**Consultation Response from KC,
Highways Development Management**

2021/90357 East Bierley Playing Fields, Hunsworth Lane, East Bierley, BD4 6PU

Works to existing sports facilities including erection of a clubhouse, additional changing facilities building, boundary treatments, storage facilities and floodlighting, works to existing pitches, and creation of new hybrid and five-a-side pitches and car park

Client	Title			
East Bierley Community Sports Association	Existing & Proposed Site Plan			
Project	Job No.	Dwg No.		
Estates Strategic Plan	EBSCA_02	04		
	Scale	Date	Drawn	Checked
	A3@1:1250	Nov 20	AW	SA

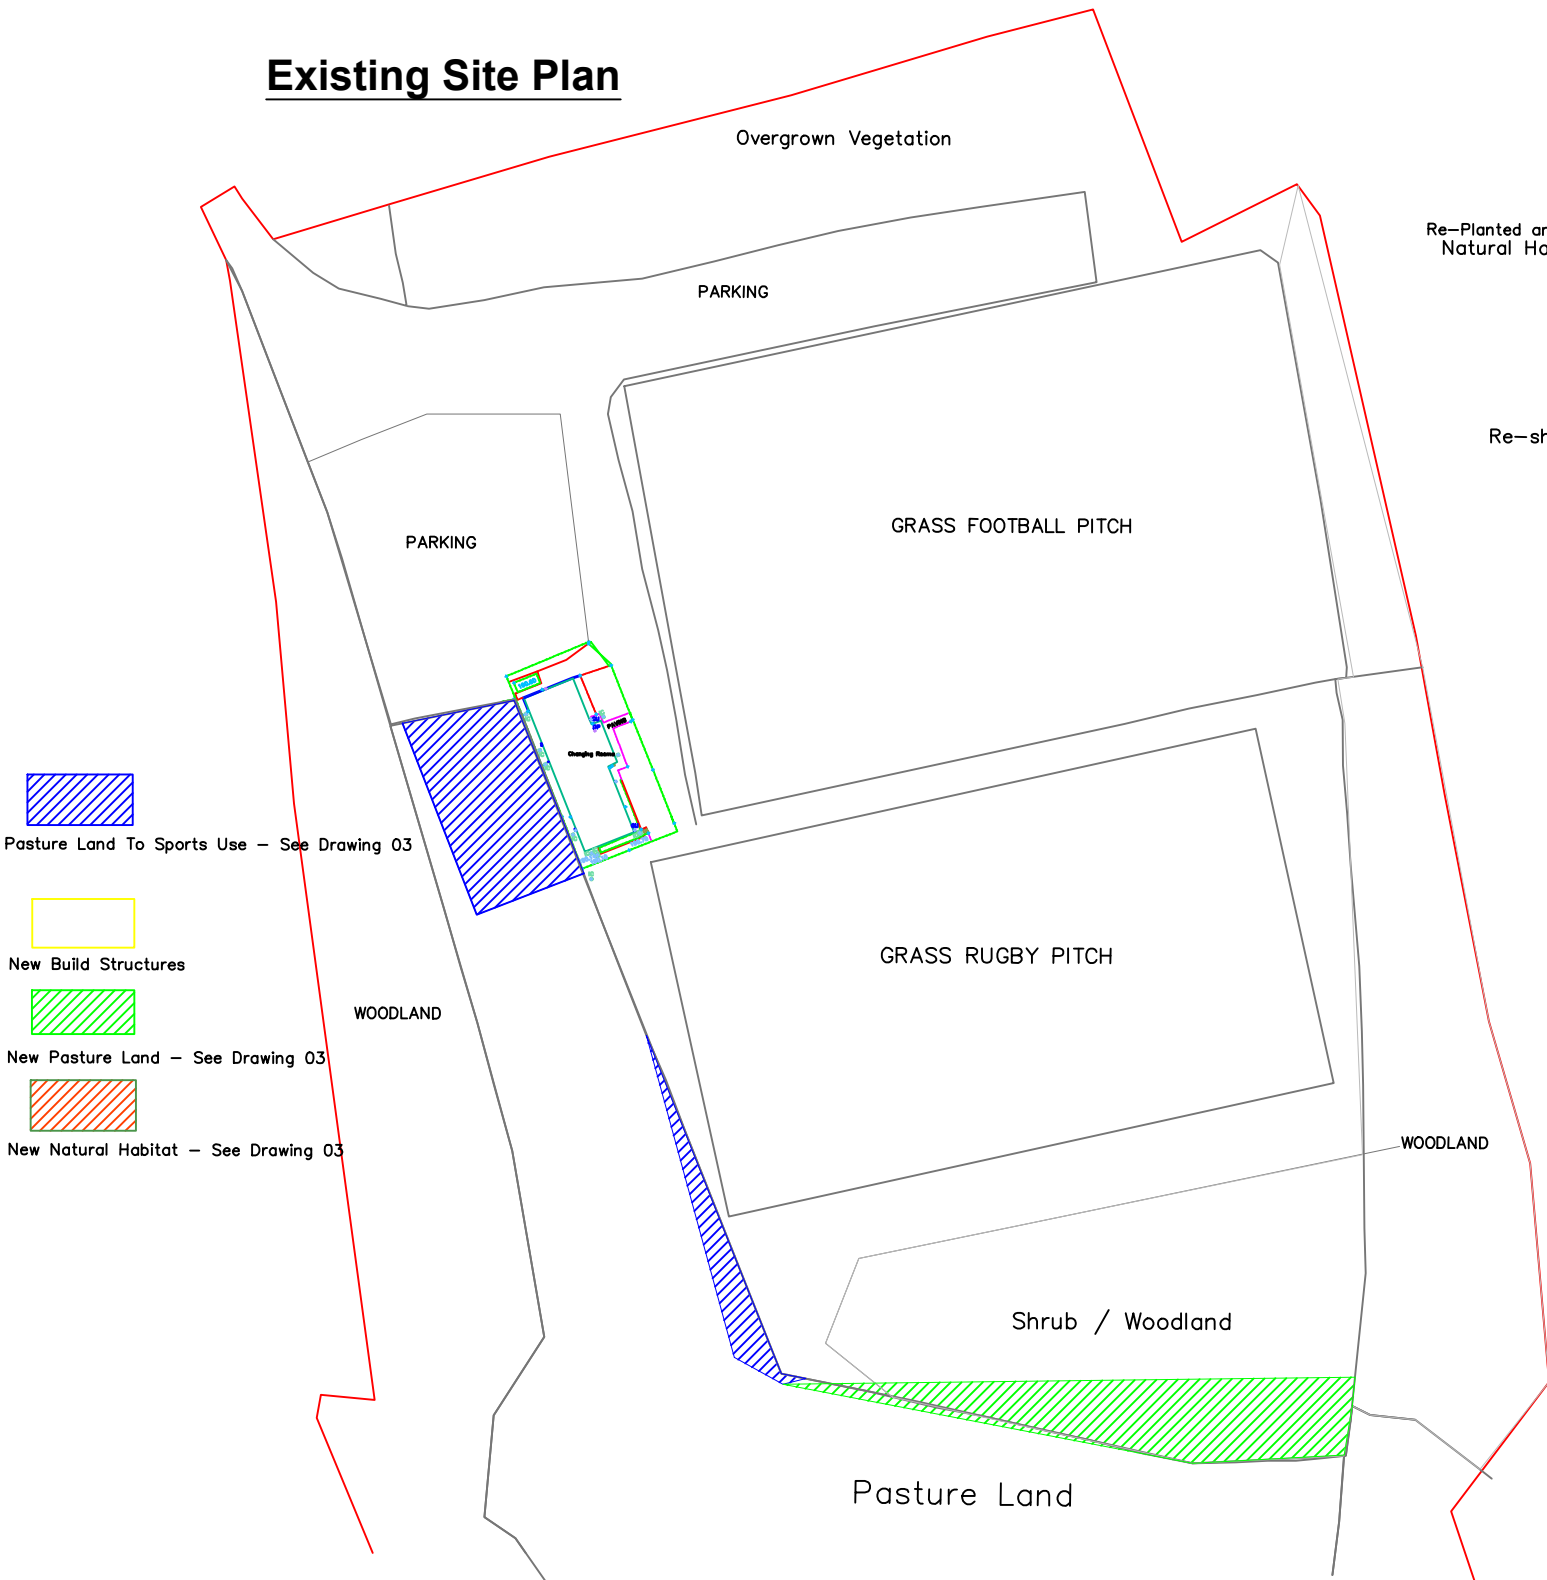
The site is proposed to be accessed from Hunsworth Lane via an existing un-made track. An undetermined planning application by Rouse Homes application number 2019/93616 shows this access improved with a new potentially adoptable road with footways leading from Hunsworth Lane to their proposed development access and along the southern frontage of their site. These improvement works do not extend to the application site boundary.

This application provides insufficient information. Further information is needed as follows:

- 1, The Highways Statement referred to in the D5 Planning Statement.
- 2, Details of the proposed access from Hunsworth Lane.
